East Anglia One North (EA1N) and East Anglia Two (EA2) Offshore Wind Farms

**Planning Inspectorate Reference: EA1N – EN010077 &
EA2 – EN010078**

Deadline 11 – 7 June 2021

**East Suffolk Council's Response to Additional
Information Submitted by the Applicants at Deadline**

Figure 1 Potential Sensitive Receptors and Areas Subject to Additional Construction Phase Controls

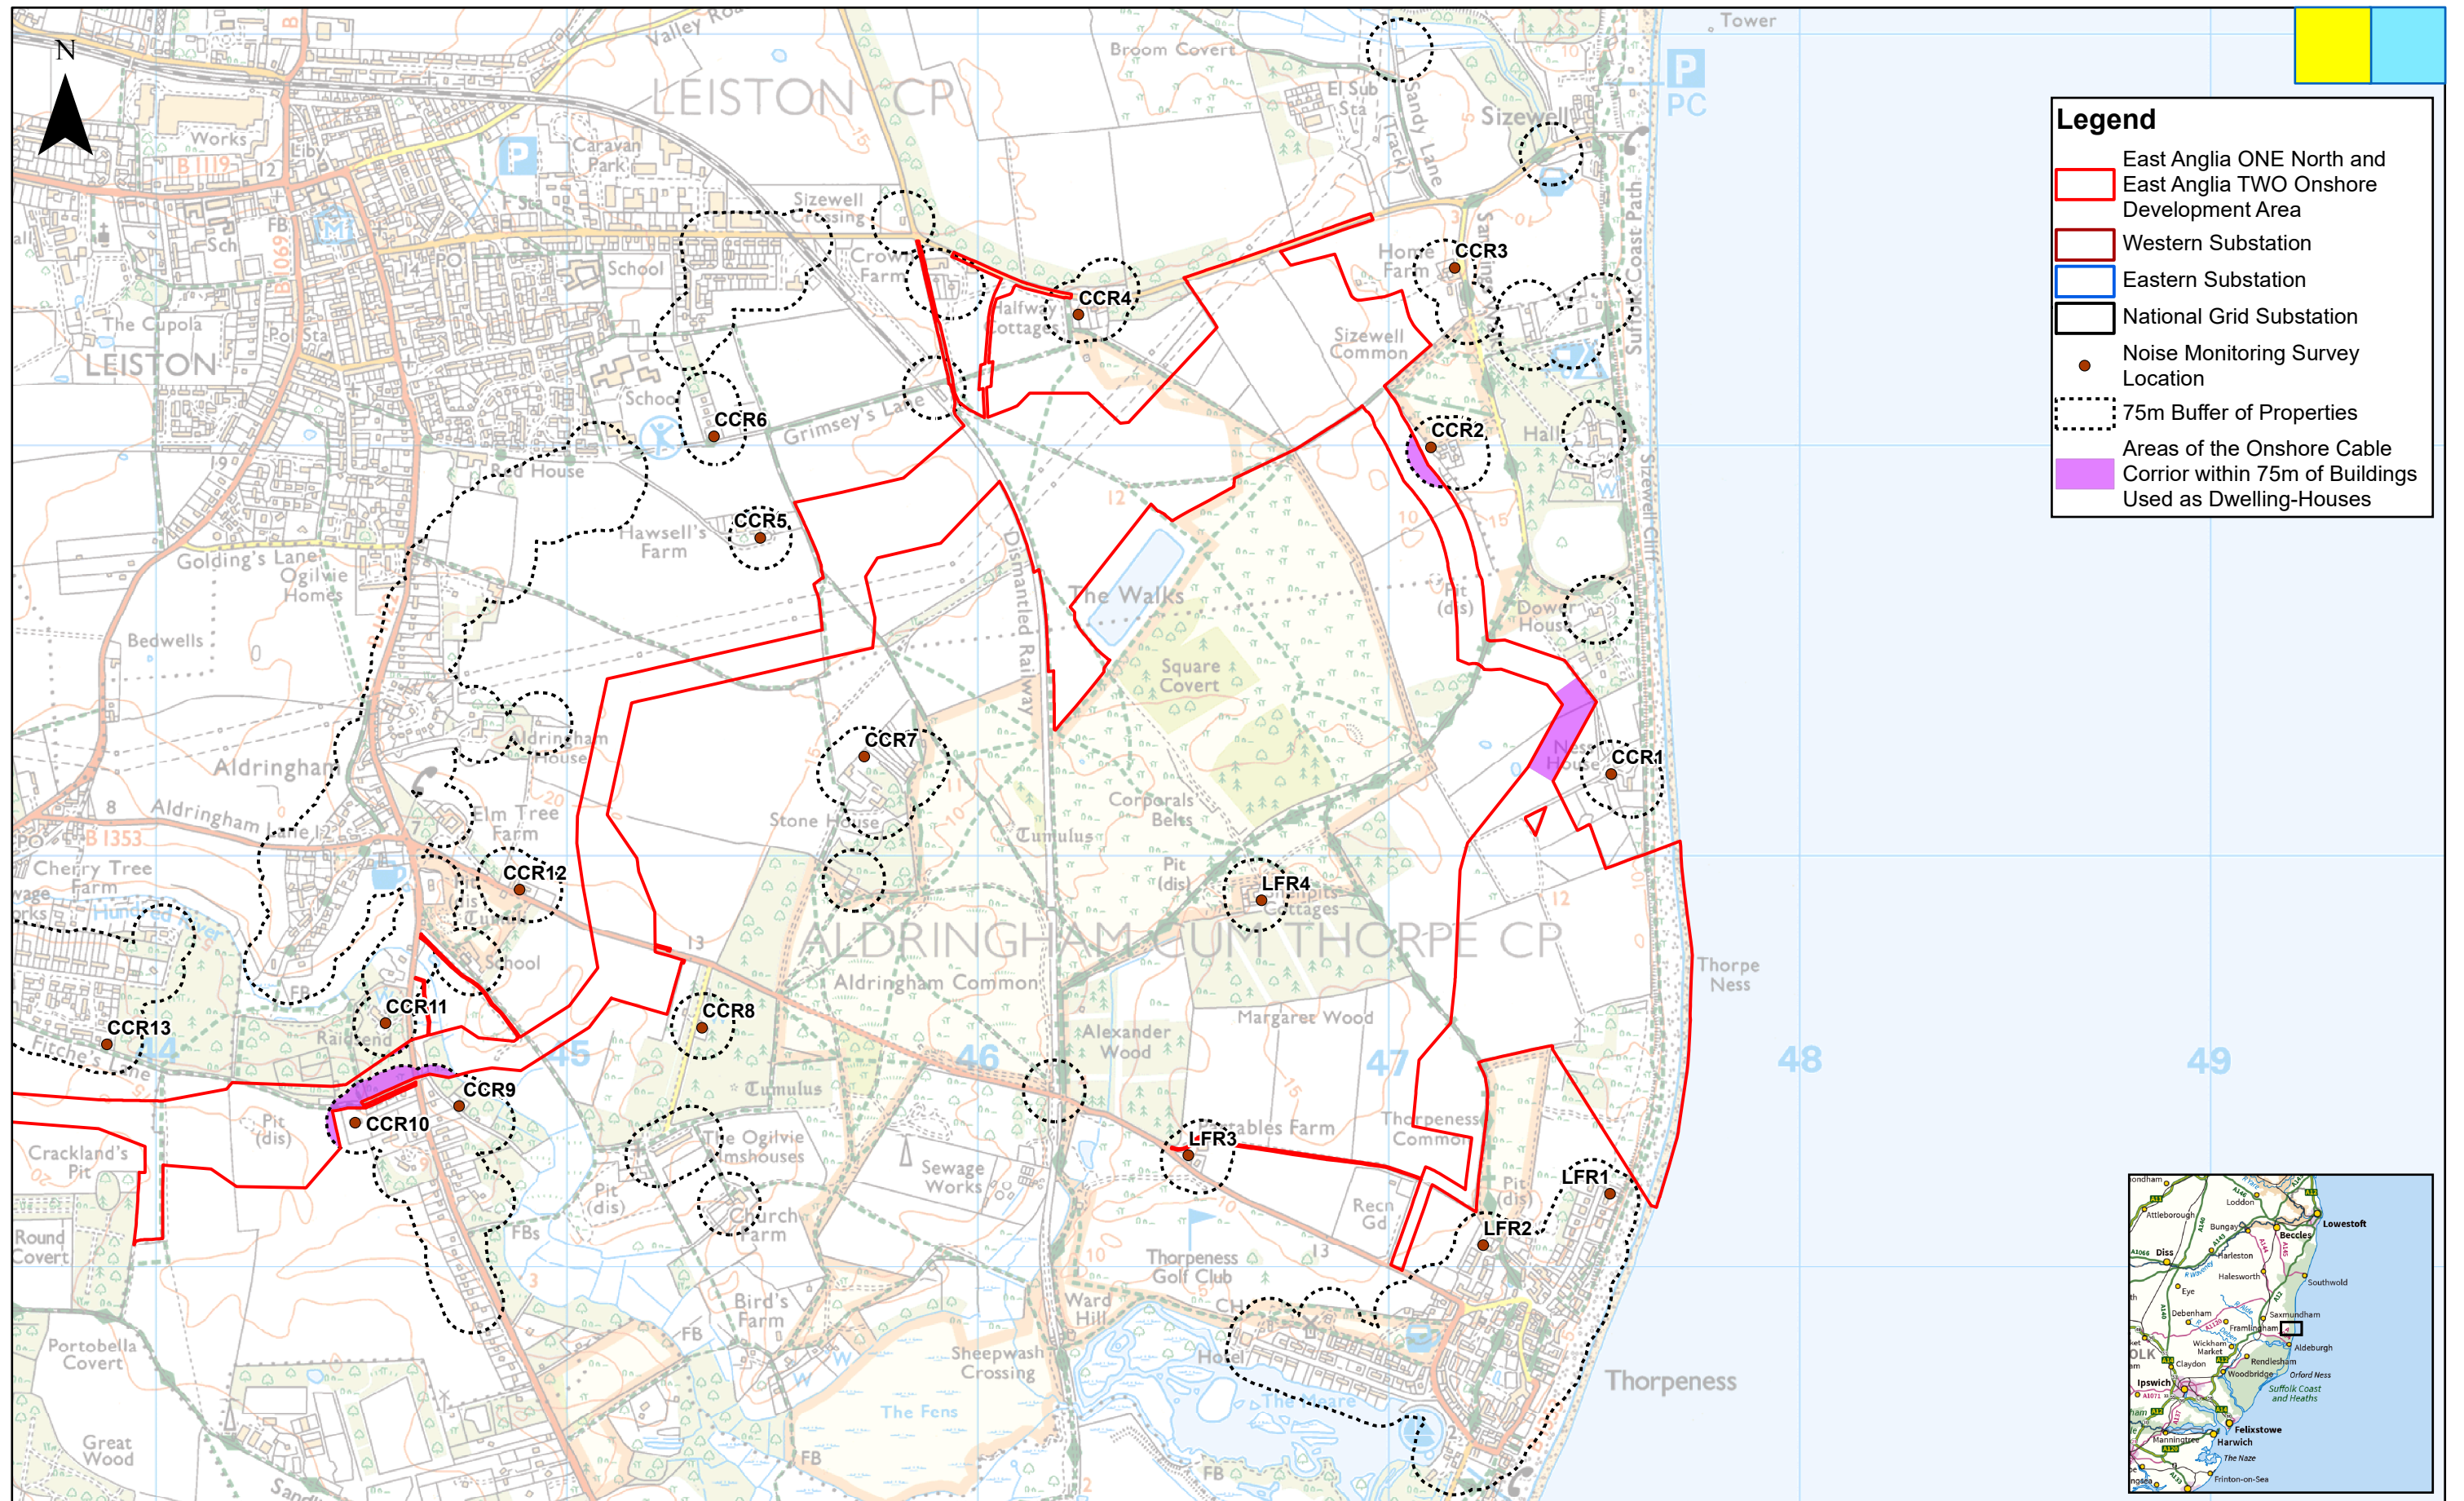
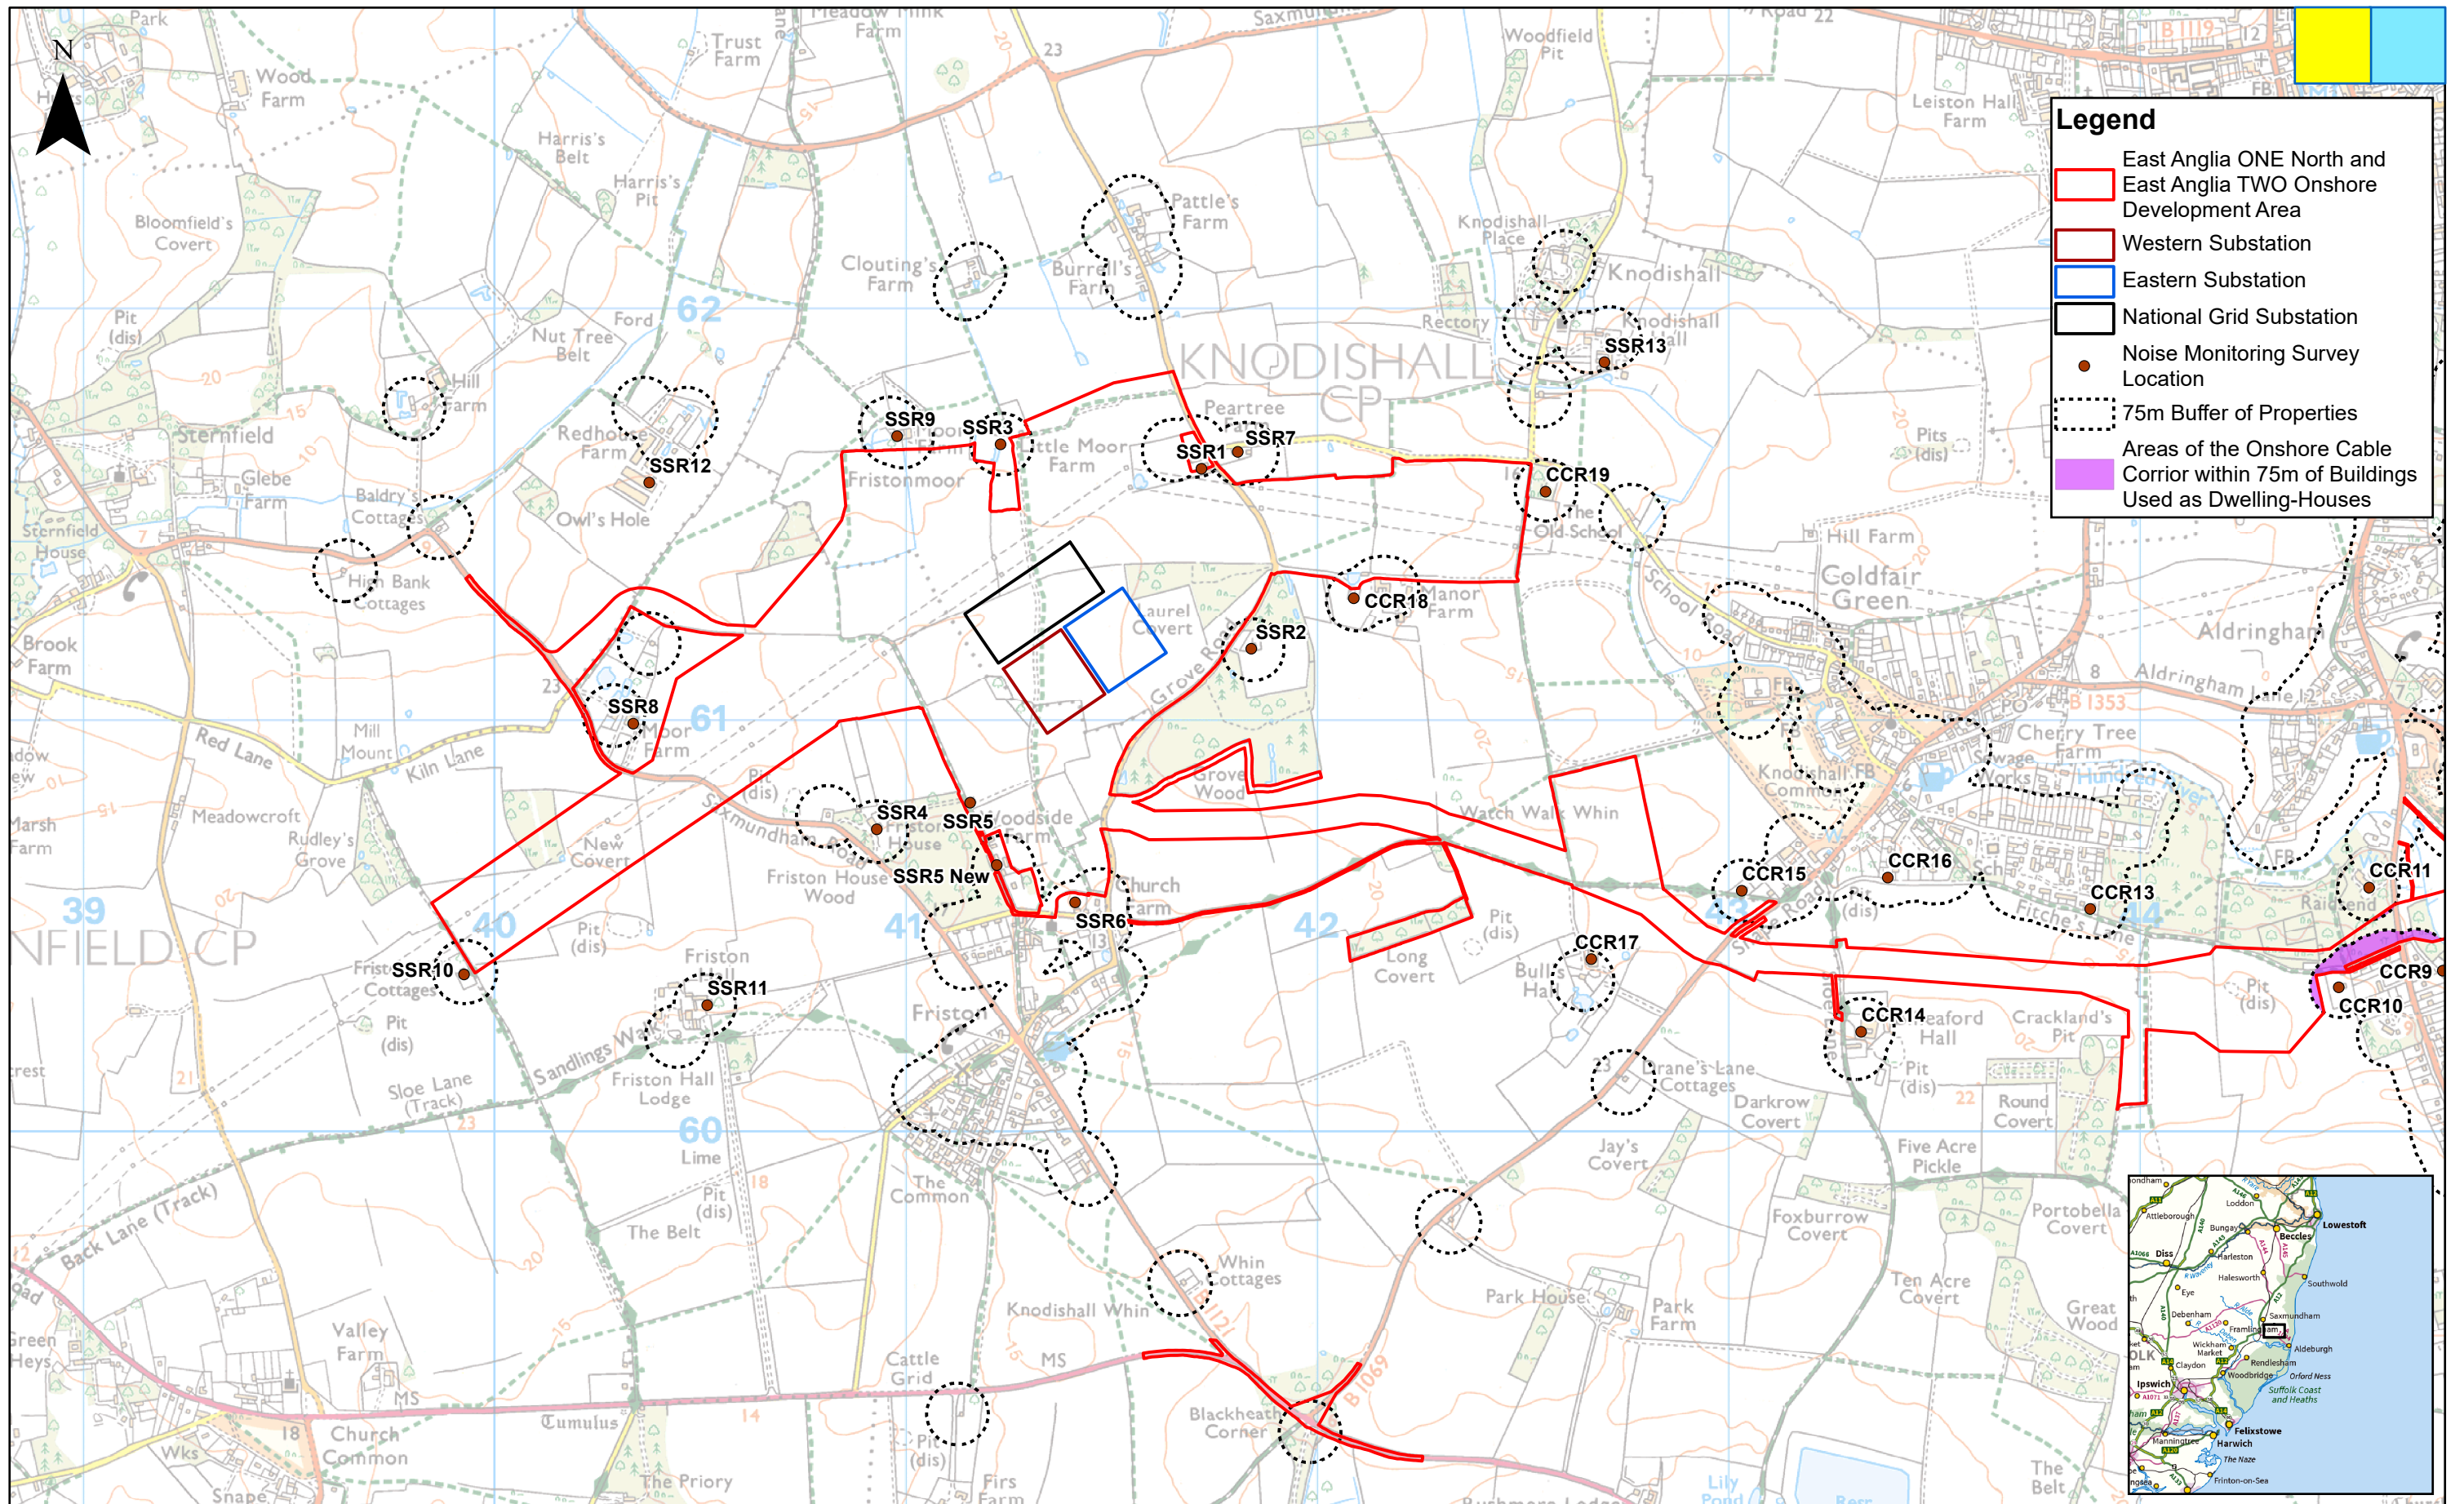
Section 3.4 Screening and Fencing Paragraph 61, third bullet point		The text within the third bullet point within this paragraph refers to the ‘Figure 1, Appendix 1’ a minor correction is necessary as the text should refer to ‘Figure 1, Appendix 2’.

ESC notes the additional ecological mitigation proposed with the use of acoustic and camouflage painted fencing in relation to protecting the Sandlings Special Protection Area (SPA) and Leiston-Aldeburgh Site of Special Scientific Interest (SSSI) from the slight change to the Order Limits and has no further comment to make on the measures.
Section 9.1.4 Specific Measures at Wardens Trust Paragraph 123, fifth bullet point		The additional measures are noted and welcomed.
Section 10 Air Quality Paragraph 133		ESC welcomes this commitment.
Section 10.1.6 Measures Specific to Non-Road Mobile Machinery (NRMM), paragraphs 145-146		<p>The text within the third bullet point within this paragraph refers to the ‘Figure 1, Appendix 1’ a minor correction is necessary as the text should refer to ‘Figure 1, Appendix 2’. The text could also be a little clearer regarding where non-compliant NRMM will be deployed. Although alterations to the text have been suggested below to add clarity, this change although desirable is not considered essential.</p> <p><i>“Use of NRMM which is not compliant with Stage IV emissions standards or later will be restricted to areas outside the 100 metre Buffer of Properties and away from designated habitat sites Potential Sensitive Receptors and Areas Subject to Additional Construction Phase Controls shown in Figure 1, Appendix 2 where practicable.”</i></p>
